Our Ref: 19/02511/PREAPP
Case Officer: Lucy Orchard-Lisle
Tel. No.:
planningadmin@hart.gov.uk
www.hart.gov.uk

PROPOSAL: Replace existing double glazed aluminium and plastic windows with wood.

SITE LOCATION: Lavender Cottage, The Street, Crookham Village, Fleet, Hampshire GU51 5SJ

Existing South Elevation Scale 1:100 @ A3

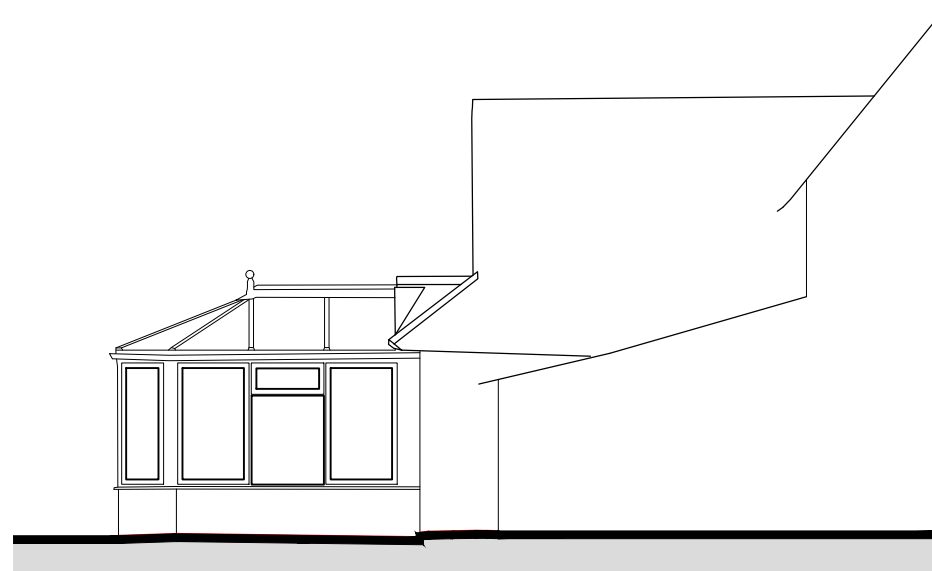
Window above the porch on the front (south) elevation:

This appears to be the oldest window in the house, and must be retained. It is suspected to date from the early C20, but could potentially be older. It also contains historic glass (identifiable by small imperfections, such as air bubbles or a wobble in the glass). It therefore holds some historic significance. The cill requires repair, but if a section of timber is scarfed in, like for like, this would be classed as a repair and not require consent.

Double glazed Aluminium windows:

All the front elevation windows, except the one above the porch, are modern aluminium. These windows have plastic strips inserted within the glazing unit to represent glazing bars. There is a further aluminium window on the rear (north) elevation in the historic part of the house. This is of the same design, and therefore likely installed at the same time as the windows in the front elevation. There is nothing physically wrong with these windows, but they are unsightly in the context of the C17 timber framed building. Lavender Cottage was photographed by the Council as part of the Council's listed building record on 26th October 1987. This record demonstrates that the aluminium windows were in situ within the front (south) elevation by this date. They are incongruous, discordant, and detract visually. Their replacement in principle would be welcomed.

Ground floor windows in the east elevation, and the adjacent window to the left of the front door:

These are single glazed flush timber windows. The bay window is unauthorised, but the window photographed in situ here in 1987 did not appear historic, and its replacement now in situ is acceptable. The window to the left of the door is in the 1980's extension, and follows the design of the window above the front porch.

Although these windows do not appear to be historic, they are nevertheless in good condition, and respect the character of the listed building. They appear to follow the design of the oldest window in the house. All these windows should be retained, as they are appropriate in design and character for the listed building. If replacement is sought (no historic fabric, so in theory acceptable in principle), these should remain single glazed, and like for like in design, because their existing design is not harmful in the first place, and therefore the harm of double glazing cannot be outweighed in this instance.

Existing North Elevation Scale 1:100 @ A3

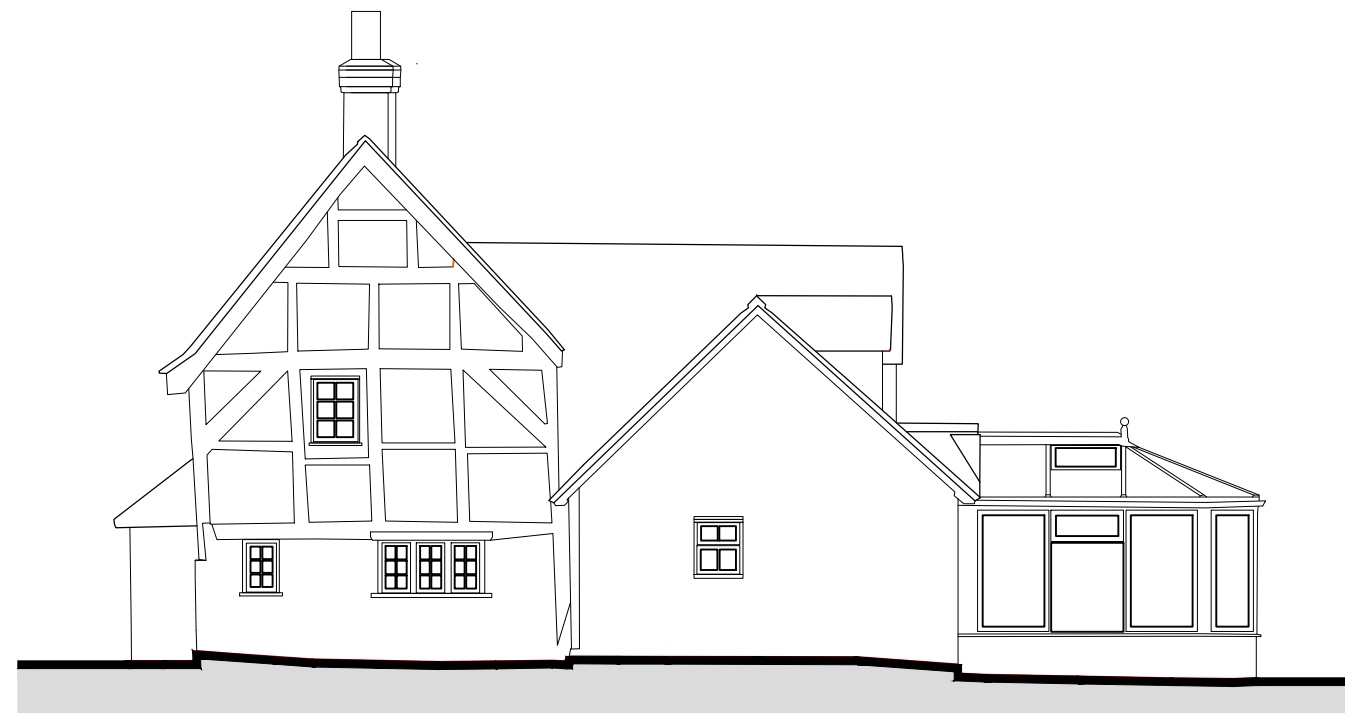
First floor window in the side (east) elevation:

This is a modern window of no significance dating from the second half of the C20, and photographed in place by 1987. It is badly decayed. Because of the era of manufacture, the wood quality is likely to be poor, and so repair is likely to be futile. Replacement is acceptable in principle. Despite being a storm proof window with a notably modern head, it is nevertheless quite slender in its proportions, so does not too look out of place. Single glazing is preferred, but a double glazed window may be conceded here if design is good, *and* an improvement on the existing.

Windows in the rear elevation of the 1980's extension:

The three windows here are notably modern 1980's windows in the modern part of the house. As no historic fabric would be lost, their replacement in principle would be acceptable. The two windows to the far left (east) are not suitable designs in the context of a listed building, and cause visual harm to its character and appearance. Double glazing could be conceded here, provided there is an improvement in overall design.

The six-light casements in the larger gable at first floor level are storm proof modern windows, but the frames are very slender, and as such they do not look out of place in the wider context of a listed building. It would be preferable if this window was retained. However, because it is notably modern, the principle of replacement would be acceptable. As this window is also within the modern 1980's part of the house, double glazed windows would be acceptable here too. If double glazed units are considered here, they must be well designed, and an improvement on the existing.
